From: [REDACTED] >
Sent: 17 February 2021 12:39
To: Planning <planning@ribblevalley.gov.uk>
Subject: Planning Application 3/2021/0076 - Mitton Rd, Whalley

Application 3/2021/0076 Queen Mary Terrace and Bridge Terrace, Mitton Road, Whalley, BB7 9JS

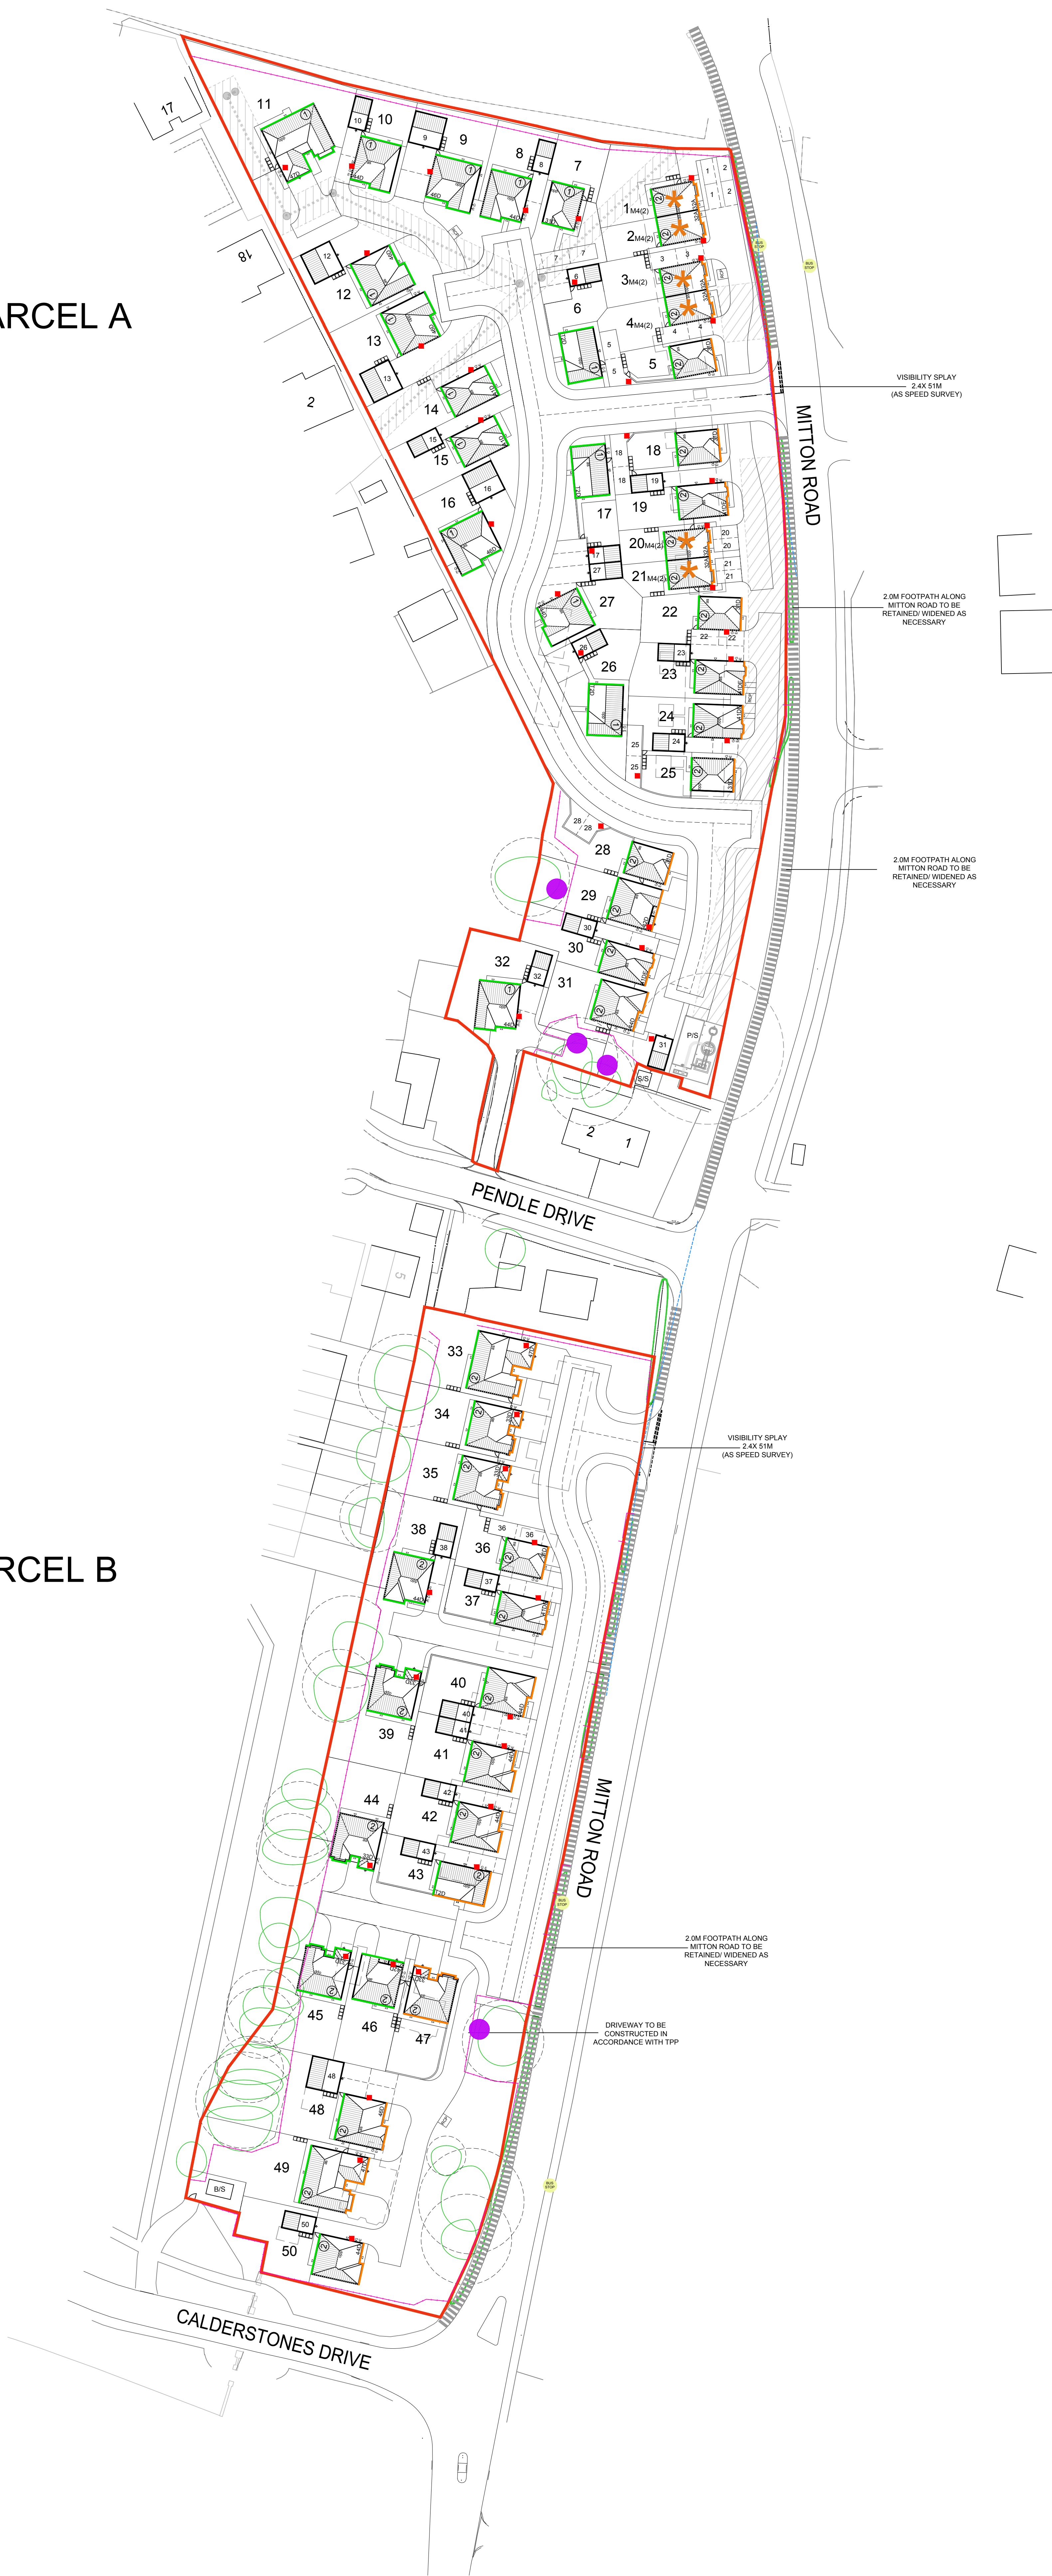
3) I feel that the proposed new junction for the entrance to Parcel B is situated too close to the entrance to Pendle Drive and could potentially cause accidents with cars turning into and exiting from these junctions. The entrance to Pendle Drive is almost always narrowed by the parked cars owned by NHS employees working the Calderstones houses. Having increased traffic along Mitton

Road, whilst cars have to come to a complete stop before entering Pendle Drive is likely to increase accidents. As the plans do not provide any provision for parking for the hospital staff, this issue will continue and worsen if the proposed development goes ahead. I therefore feel that some provision for parking for the staff should be considered in the plans. Would it also be possible for yellow lines to be laid along the entrance to Pendle Drive, up to the junction with Oakdale Drive? This will prevent obstructions for Calderstones residents entering via Pendle Drive and potential parking overflow from the new development. I have seen refuse lorries, delivery trucks and school buses all struggle with access to Pendle Drive due to the parked cars, and have stopped on Mitton Road at the junction before proceeding into Pendle Drive. Currently, the NHS staff have some parking behind the Calderstones house at the end of Queen Mary Terrace, but clearly this is not currently sufficient and has been removed from the plans altogether.

4) It is a general concern among residents including myself that there are too many trees and hedgerows marked for removal, particularly in Parcel B. The guidance detail on the Arboricultural Impact Assessment states that removal of trees should be avoided between March to August to negate the effect on wildlife. However the planning application states that Prospect Homes wish to commence in summer 2021. This therefore needs to be considered. Wildlife will be considerably affected by this proposed development. Can the number of trees to be felled be reduced?
